ENG-PUDSP21010-R6-PDR.pdf Markup Summary

**PROPOSED DRAINAGE MAP**

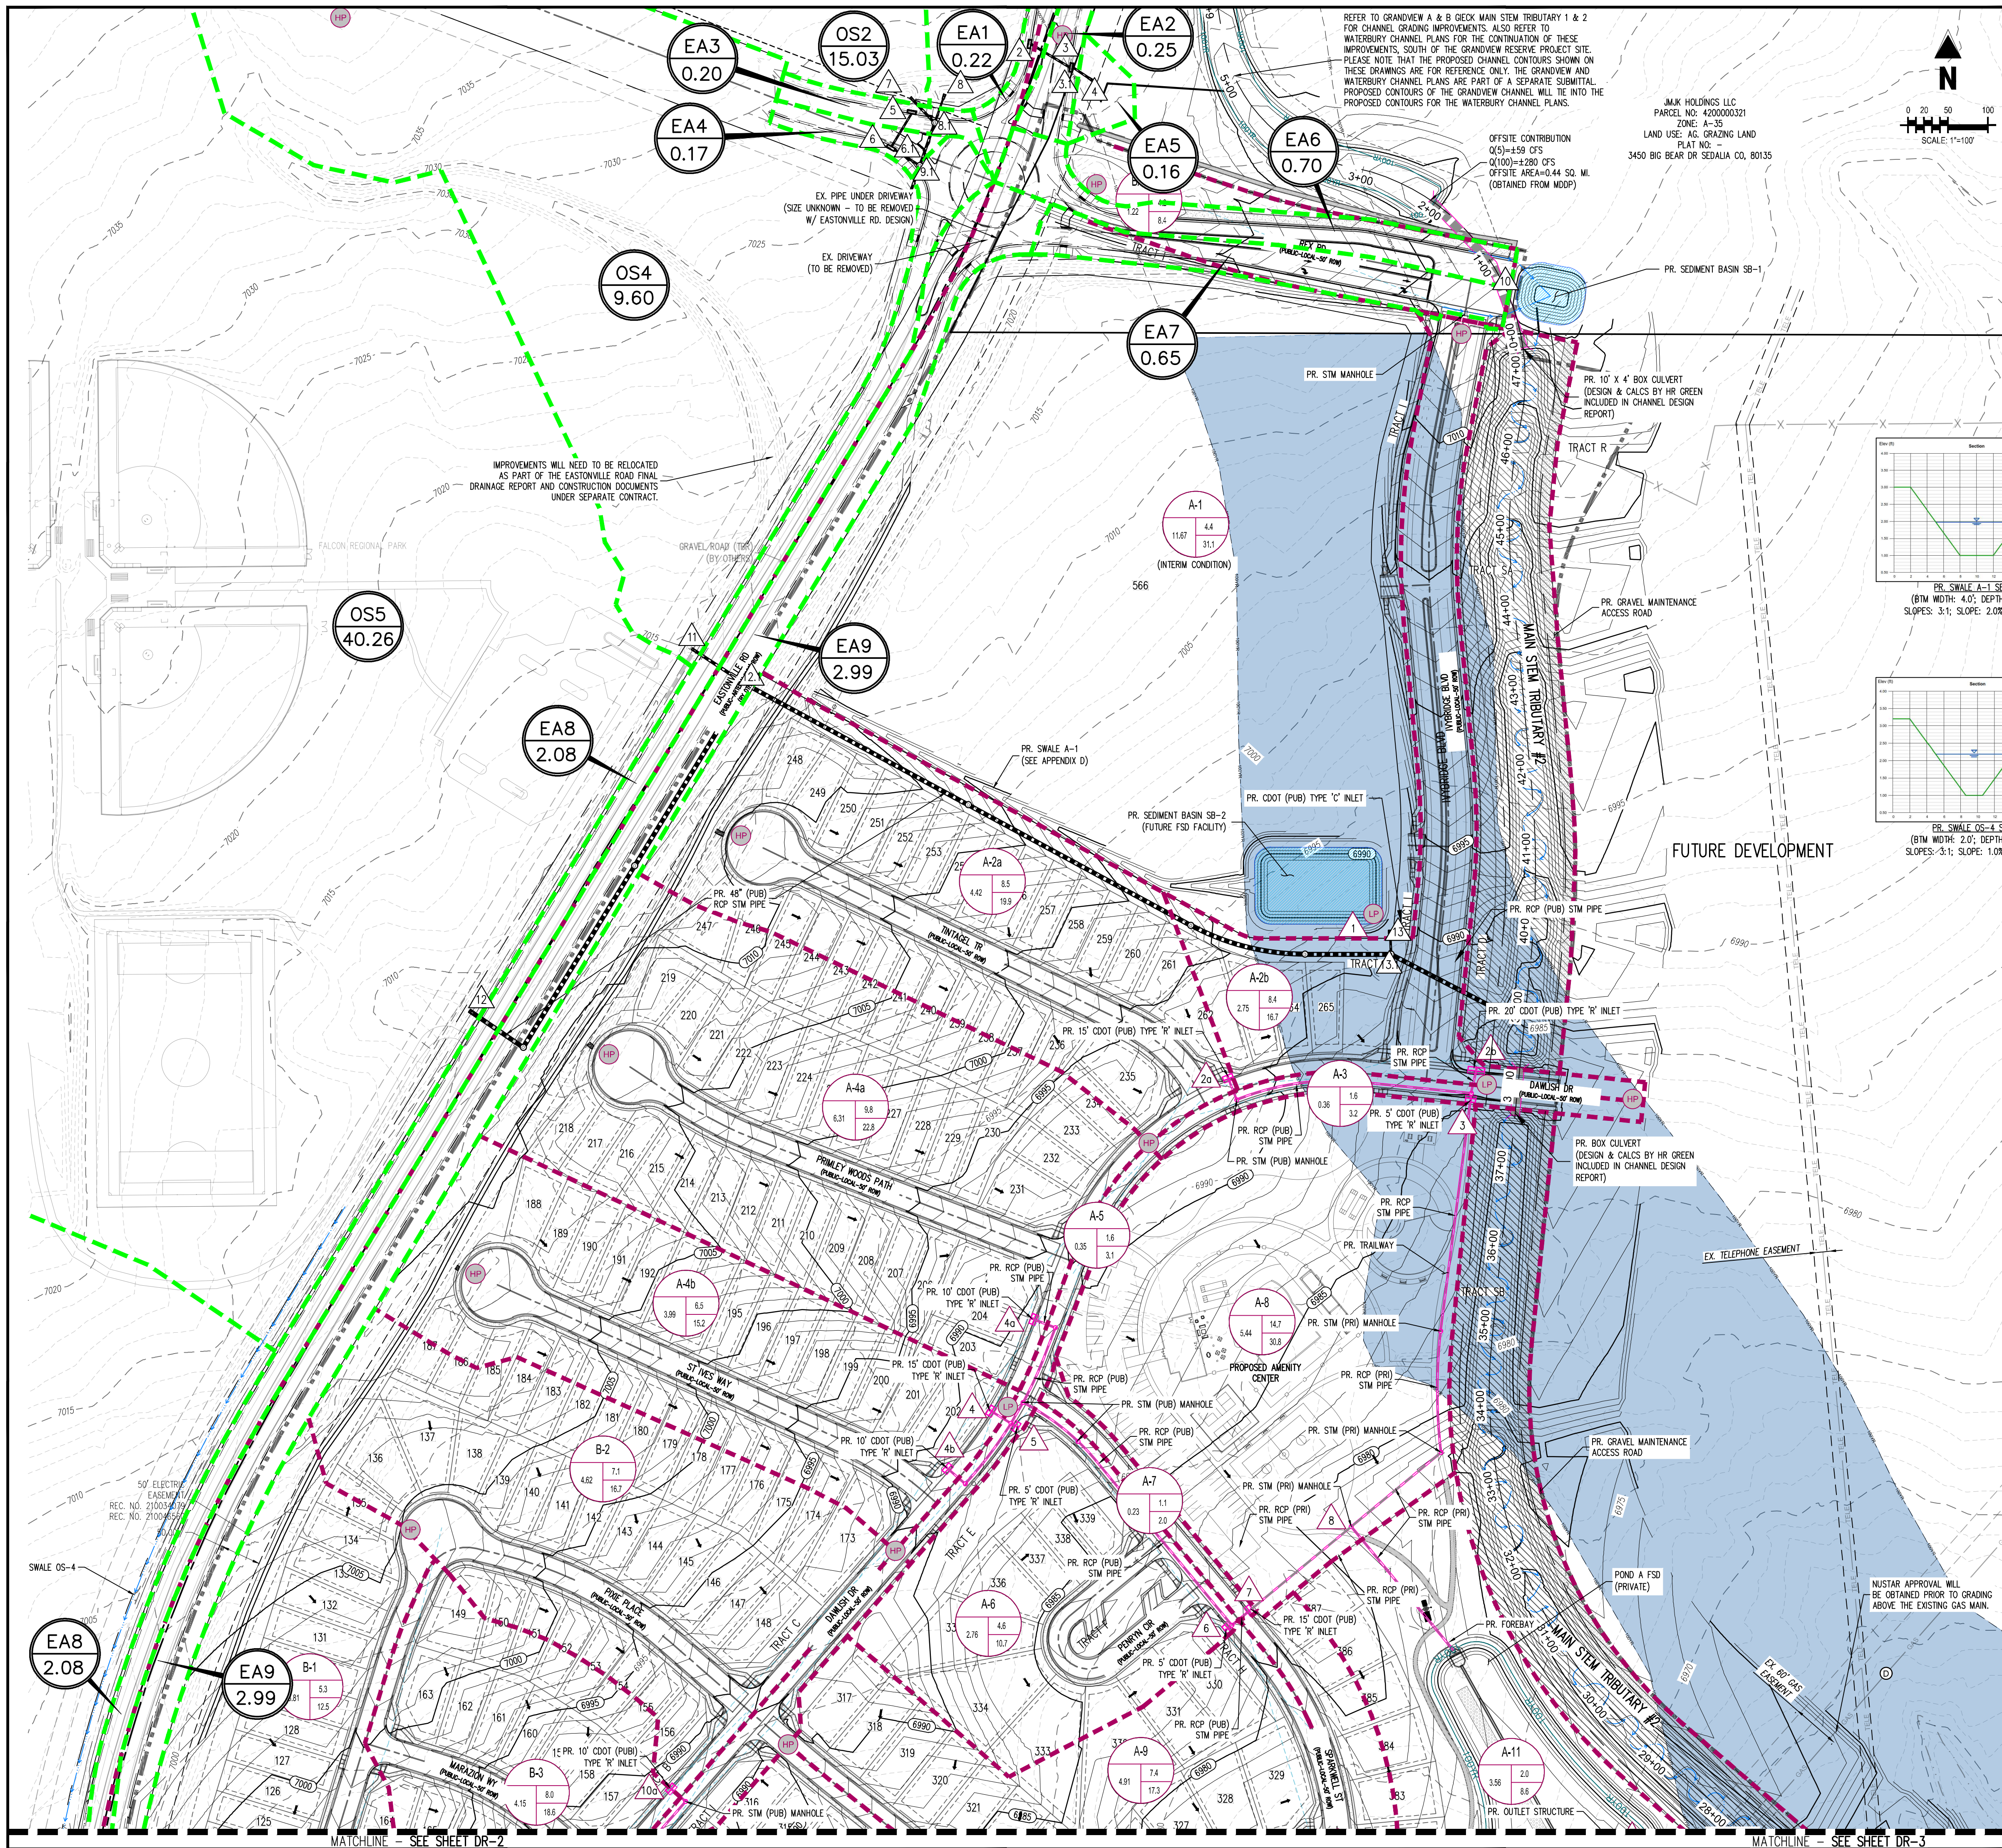
Rename one set of design points to avoid duplicates

Include all design points

Provide table for offsite / Eastonville Road basins also

Provide total offsite contributing areas

Add labels for Channel A and Channel B

PROPOSED DRAINAGE MAP

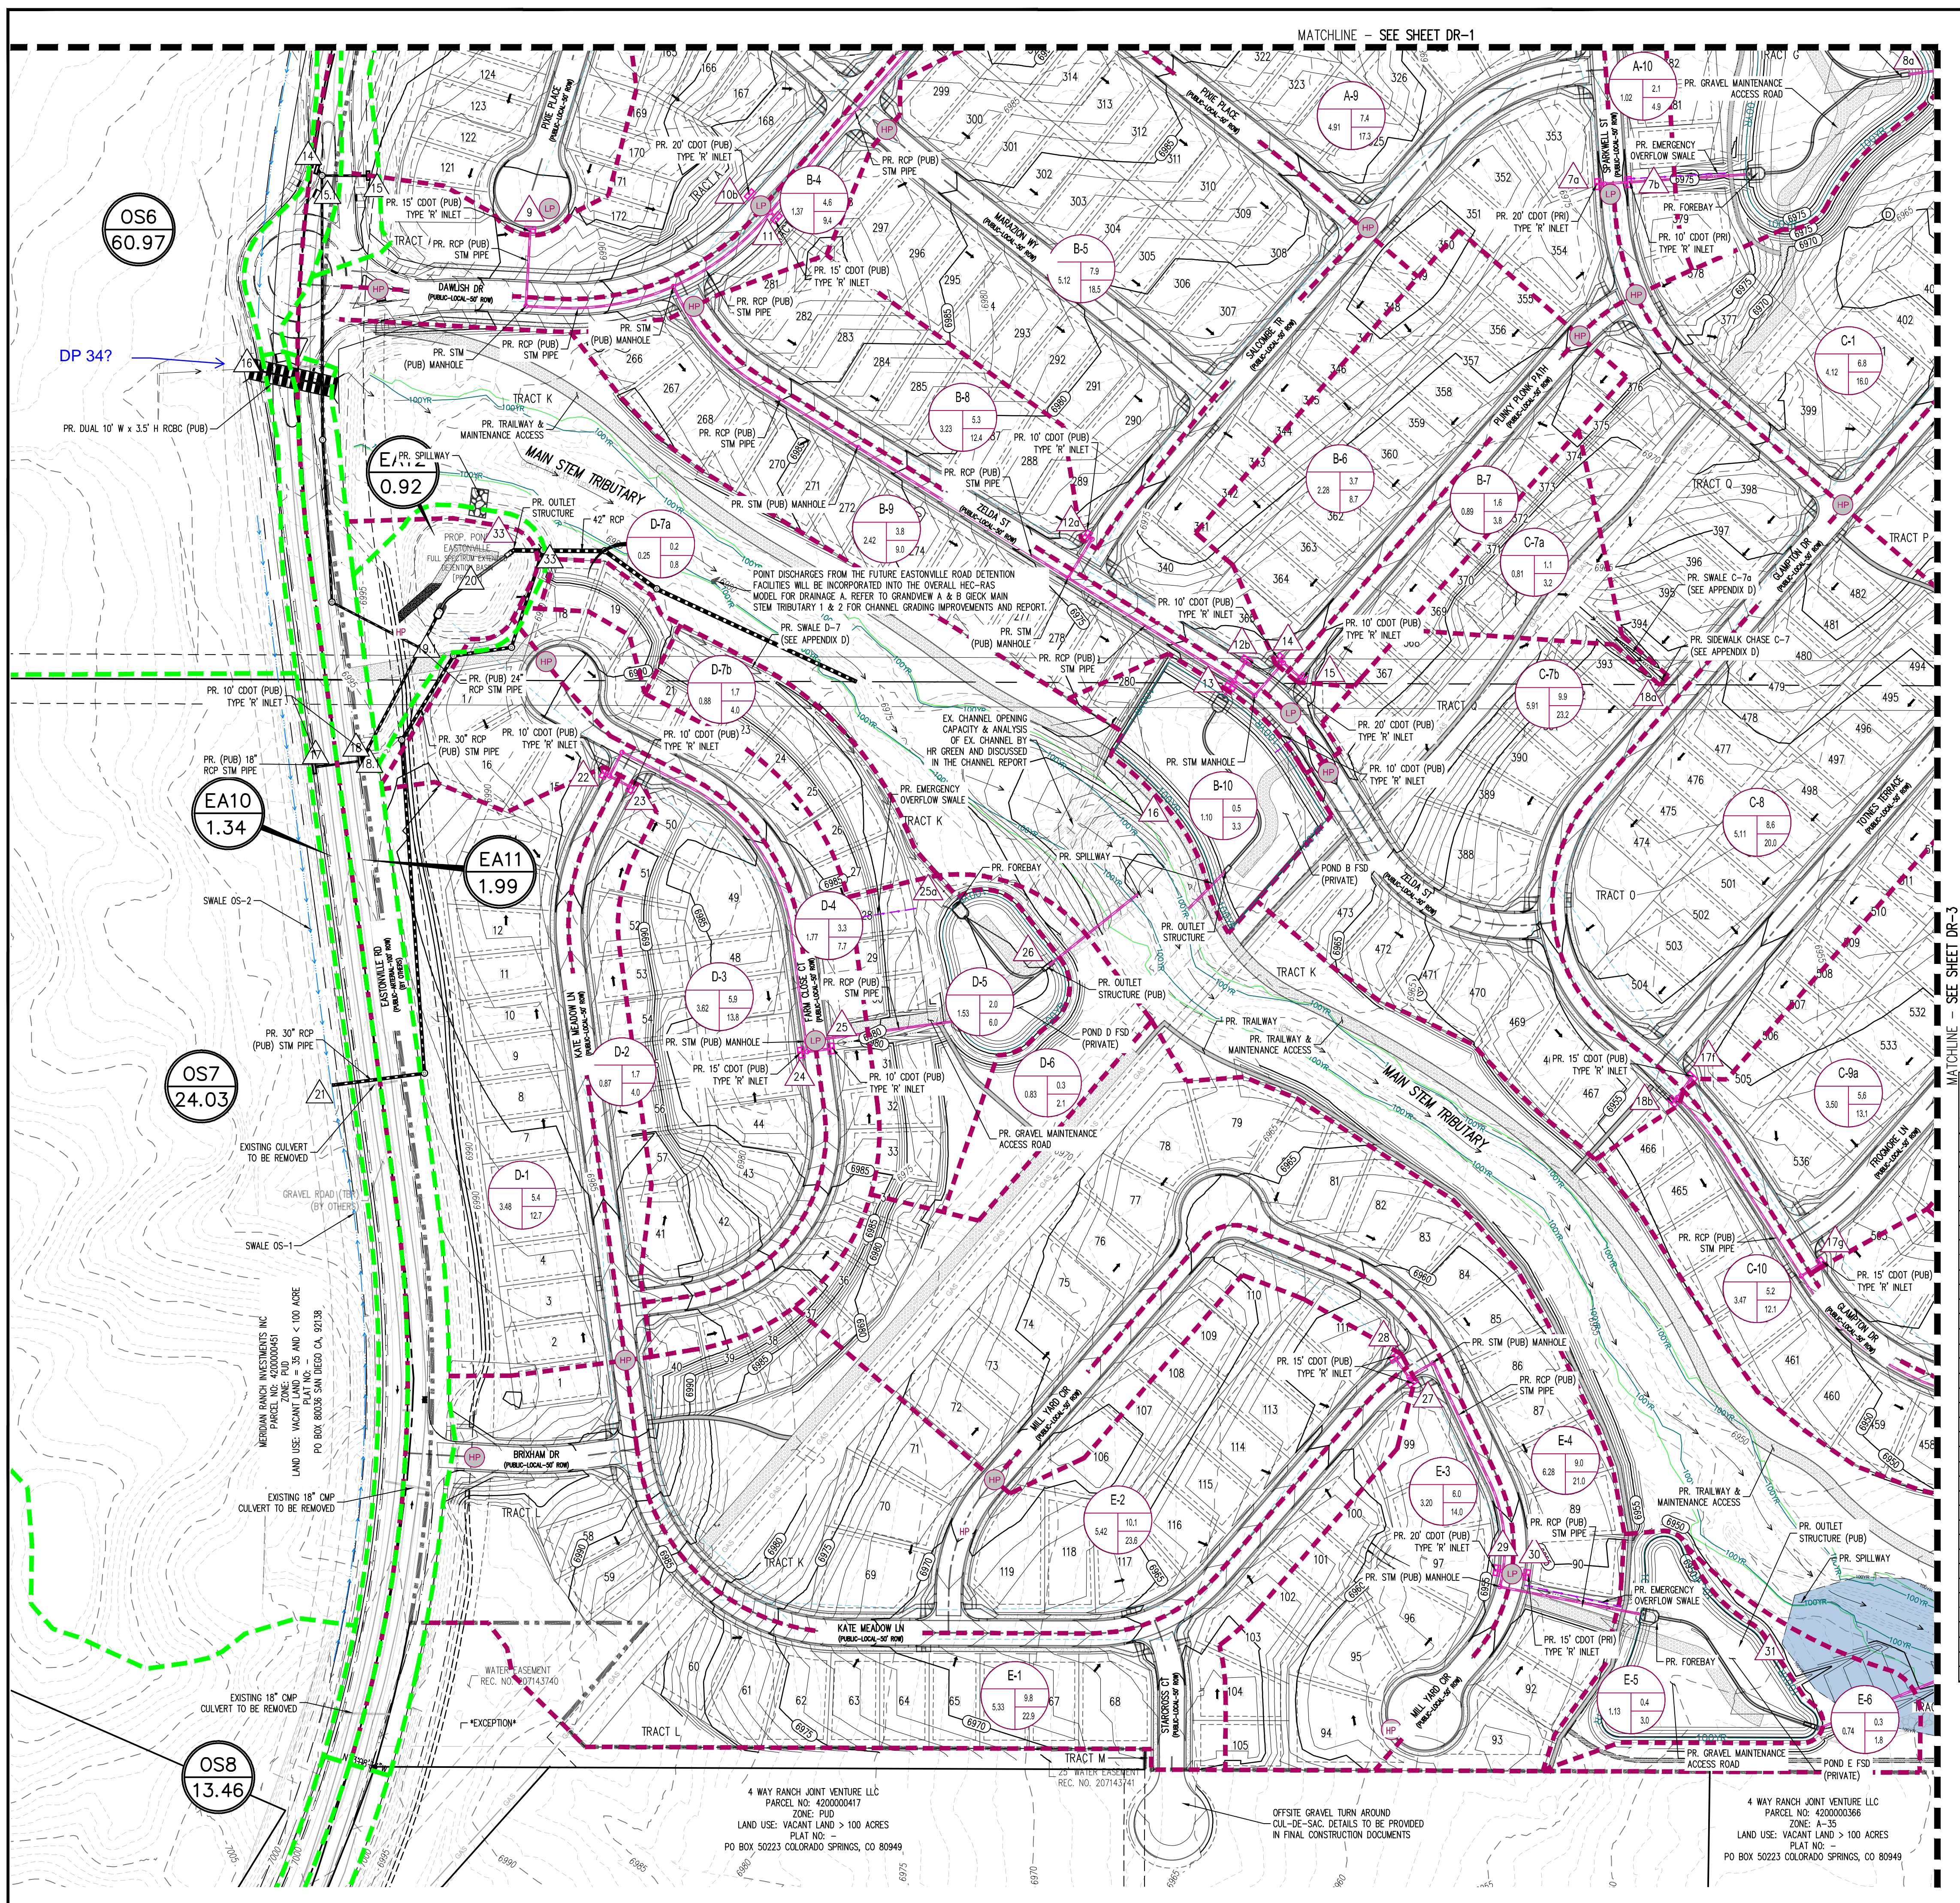
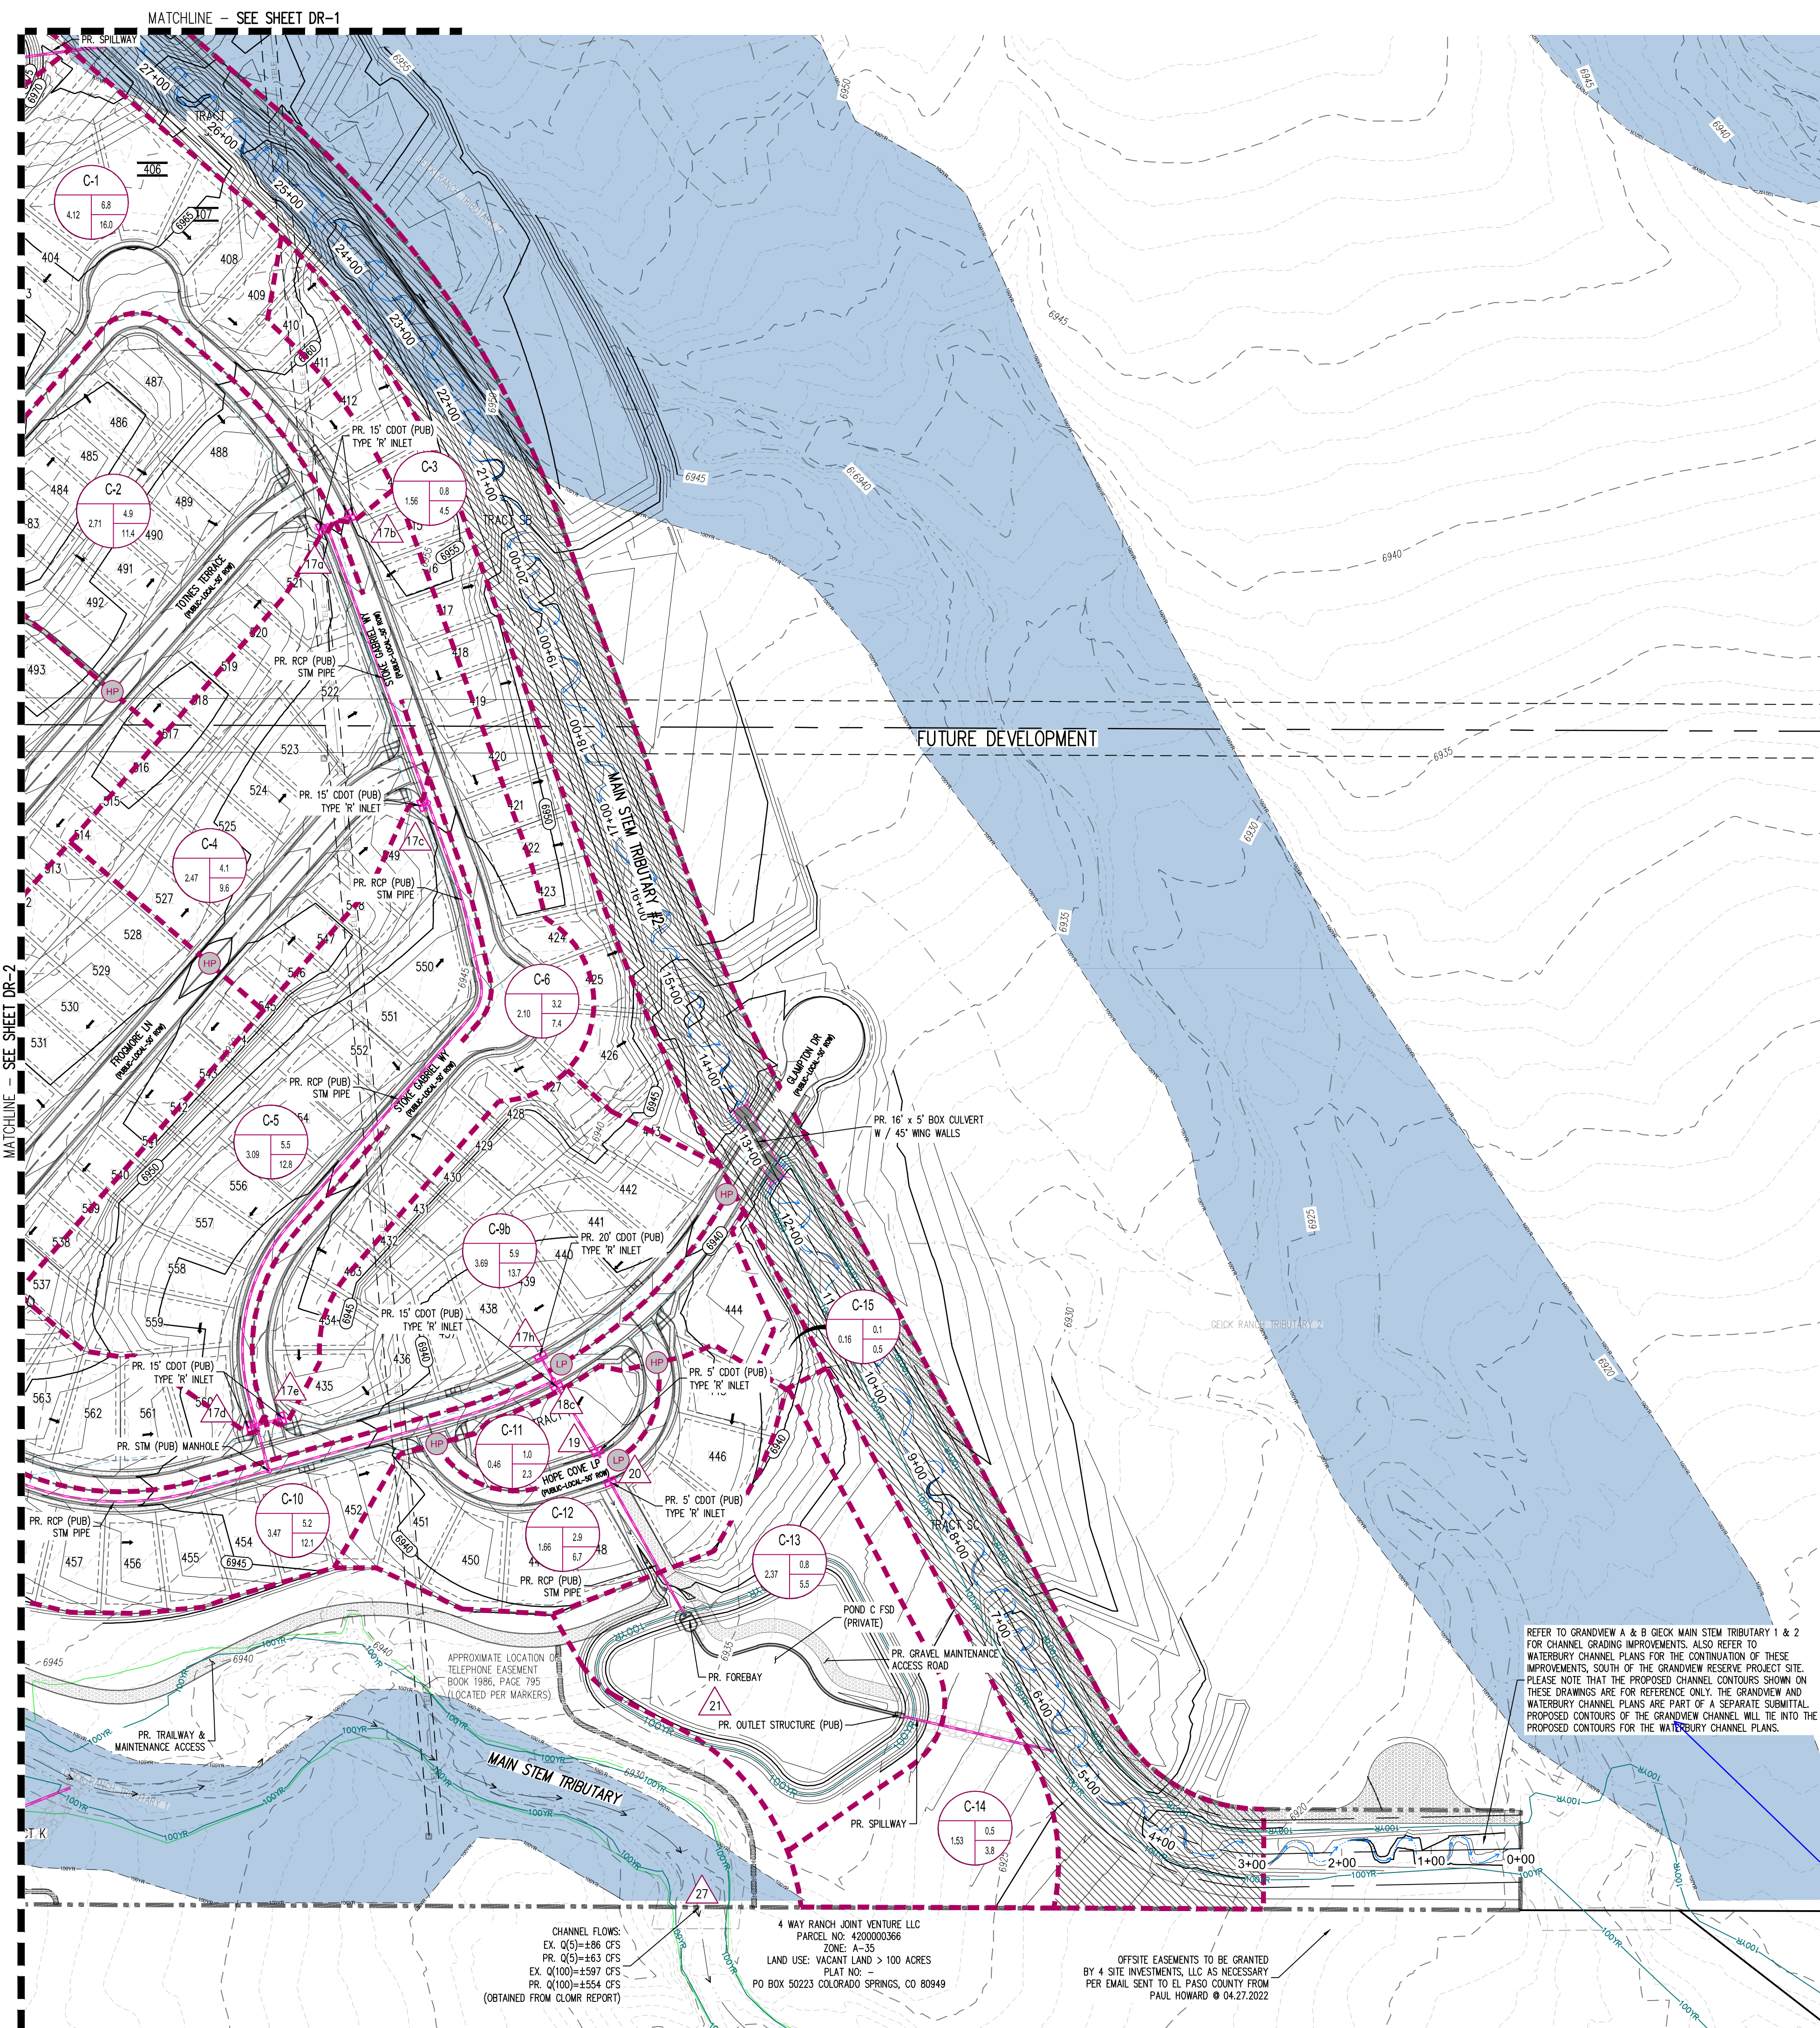
Roundabout wouldn't be here for interim?

Include all DPs along Eastonville also

Label total flows at the major design points

Rename one set of design points to avoid duplicates

Should overflow spillway be on this side?

Should overflow spillway be on this side?

Clarify timing of road construction and culvert removals - will Eastonville be constructed prior to overlot grading?
